From: Claire Potts
Sent: 19 December 2017 09:13
To: Planning.Responses
Subject: FW: Nyton Nursery Application AL/102/17/RES

Please could the additional representation below be uploaded to the file AL/102/17/RES

From: [REDACTED]
Sent: 18 December 2017 21:01
To: Claire Potts
Cc: Aldingbourne Parish; David Maddox; Martin Beaton
Subject: Re: Nyton Nursery Application AL/102/17/RES

(Figure 1; Photograph from Nyton Road; T15 circled)

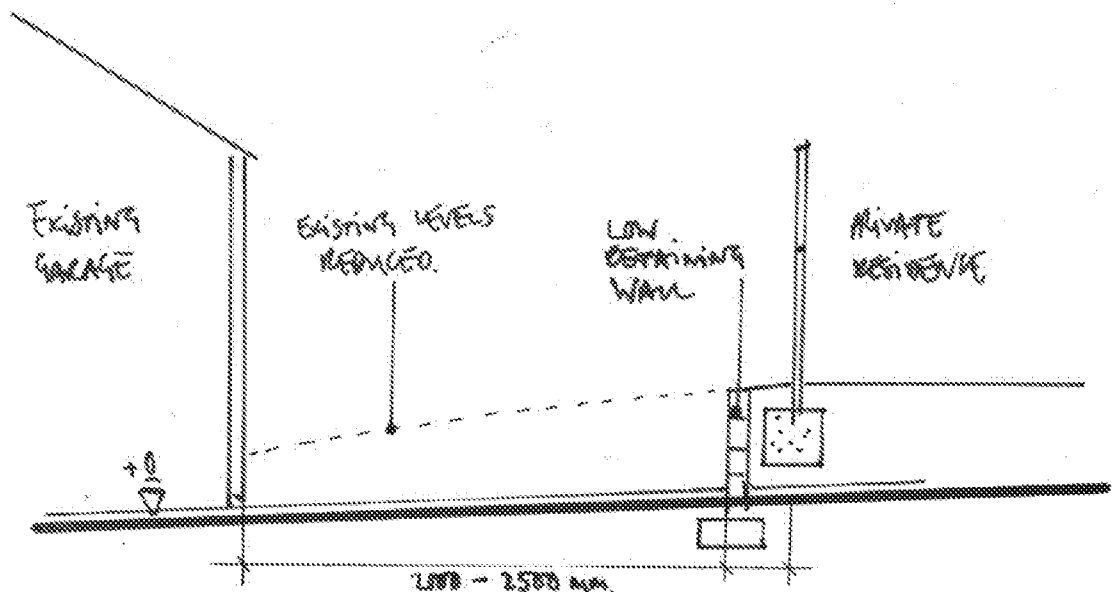
- The fact that the base of the tree is higher than the road has now been acknowledged.
- It is noted that the tree has been pruned which has left the tree with an imbalance. This work was carried out illegally by the contractor working on behalf of Arun Veterinary Group and we advised the Council at the time it was happening. A Tree Officer did attend site and has since written to them, but decided not to take any action. It would be very unjust if this illegal work can now be used as a reason to fell this substantial tree. We think that the impact of this branch being removed may be being overstated in order to justify its removal.

(Figure 4; Illustrative sketch section across proposed footpath showing tree retention / stepped access)

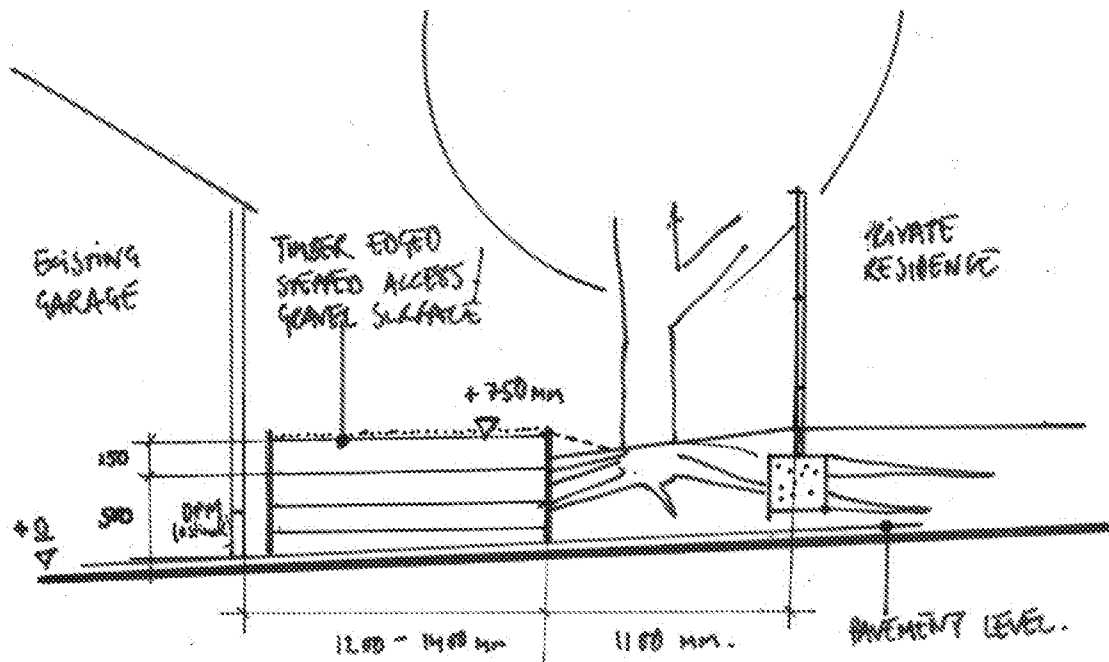
- The sketch showing the retaining wall is exactly what we feared would be required. In order to construct this wall the foundations of our fence will be undermined which will destabilise it. Also, the roots of our Laurel Hedge, which gives us essential screening will be severed, causing it to die.

- This option will require Party Wall consent which we will obviously not be agreeing to.
- The option to retain the tree and introduce steps would be much more preferable as it will ensure our hedge is retained and our fence undamaged. The Parish Council have proposed a route for the cycleway further to the east which seems much more practical. As I have pointed out before there is no space to slow cycles down before meeting the road and the alternative location off Barnett Close would be much more safe.
